Notes of meeting on 18th February 2014 with Arun District Council

SUBJECT: Reserved Matters Application. Land to the rear of Fellows Gardens, Yapton. Planning Ref: Y/30/13

Fellows Gardens Yapton

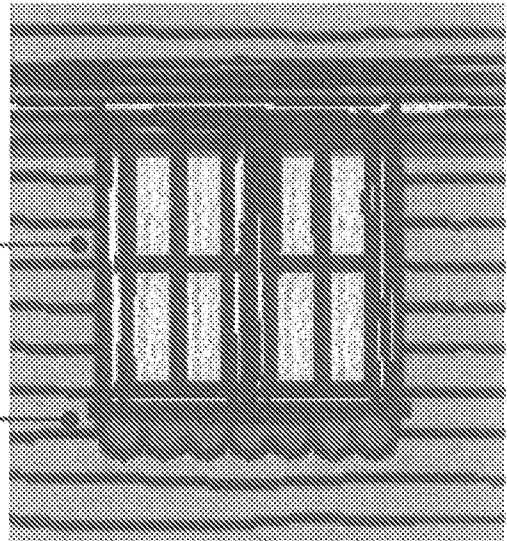
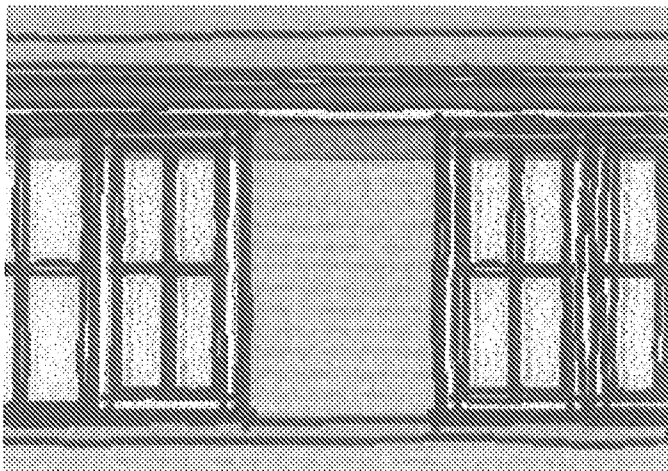
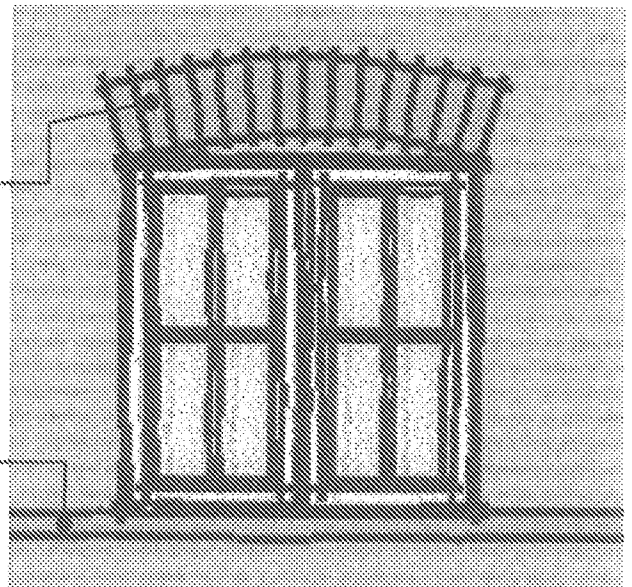
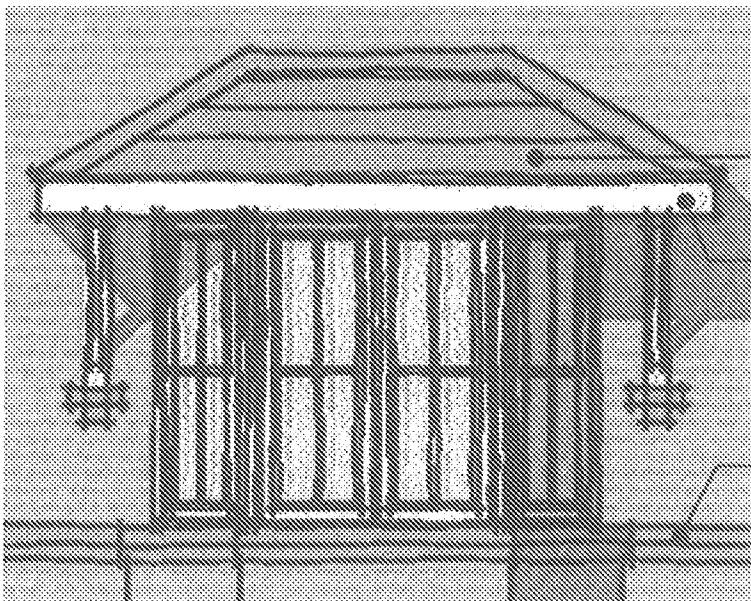
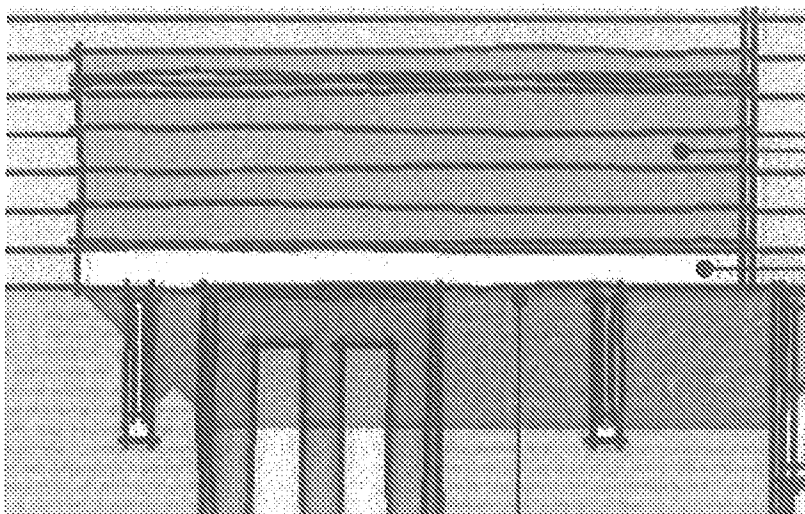
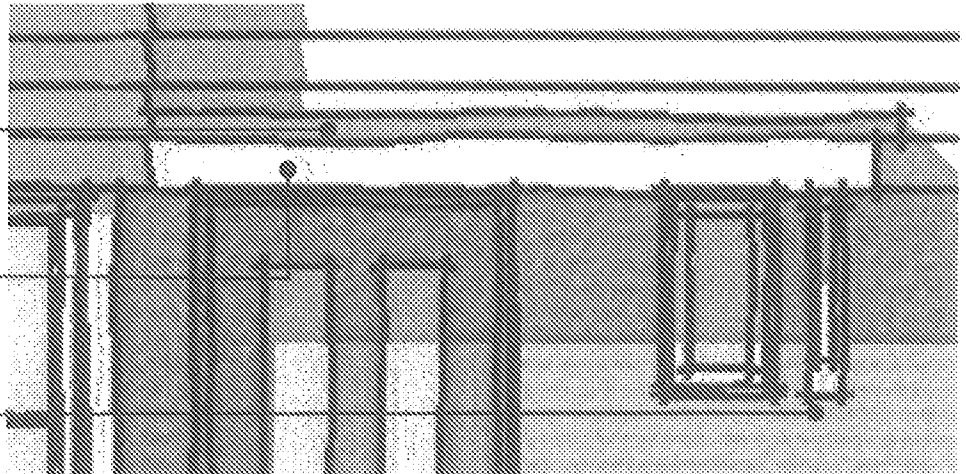
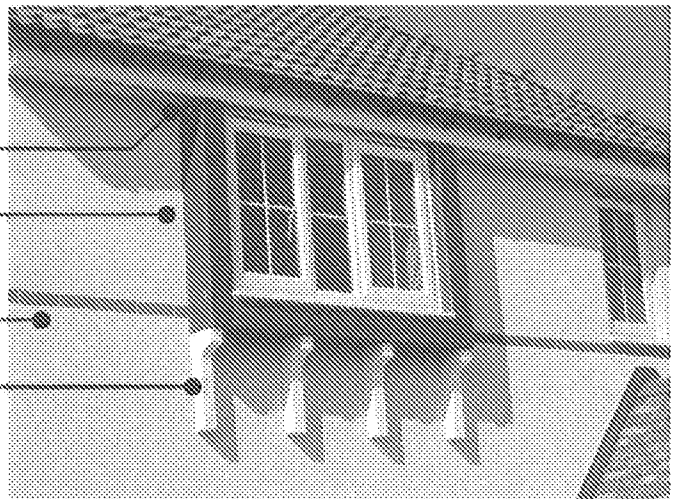
- Submitted plans should show depth of window reveals (70-80 mm)

- a. Brickwork Cills
 - b. Brickwork Soldier Coursing
 - c. Depth of overhang for roofs (300mm suggested)
- 5) Improved landscaping in the following locations will be important as they are susceptible to being used as overflow car parking spaces or important to the amenity of the site:

Drg No: 48-1963-GAR-001

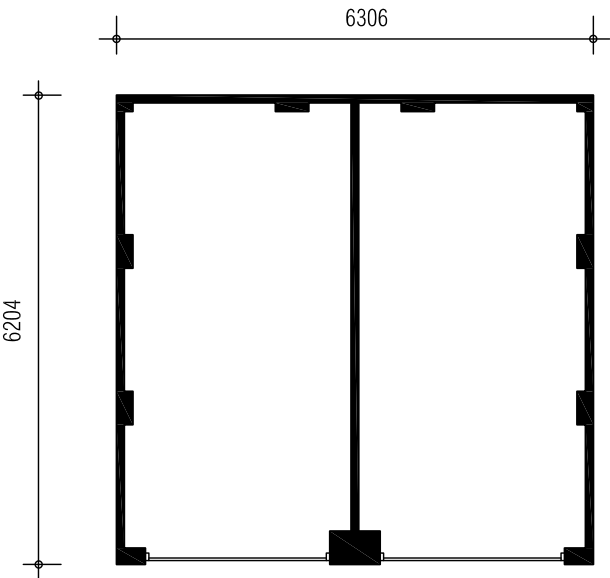
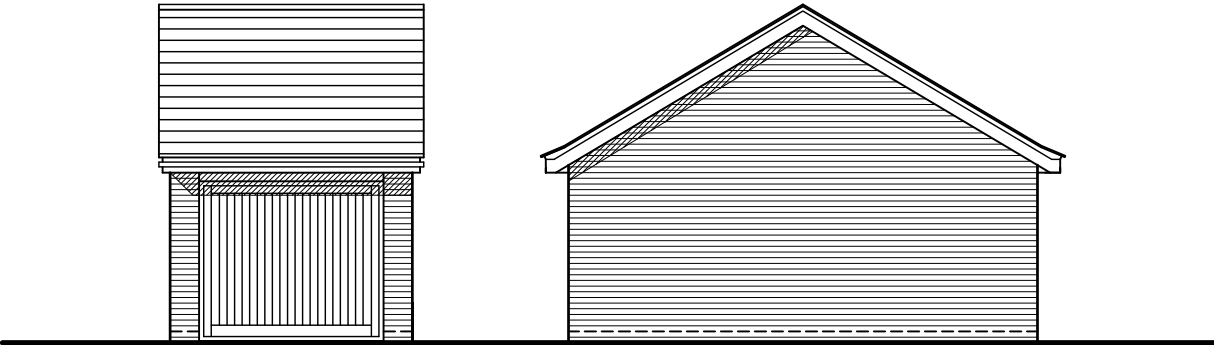
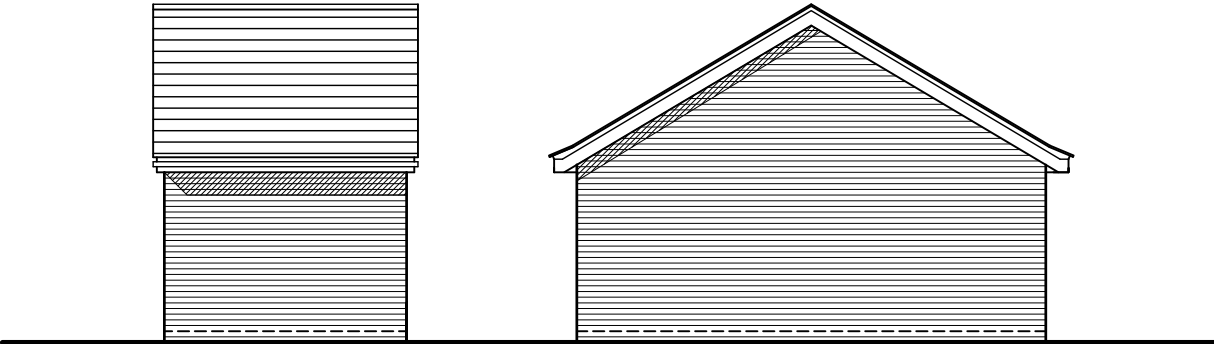
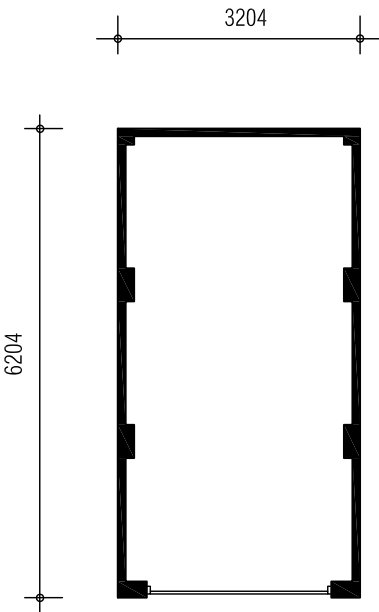
- Garages should measure 6m x 3m internally – this was confirmed by Bellway
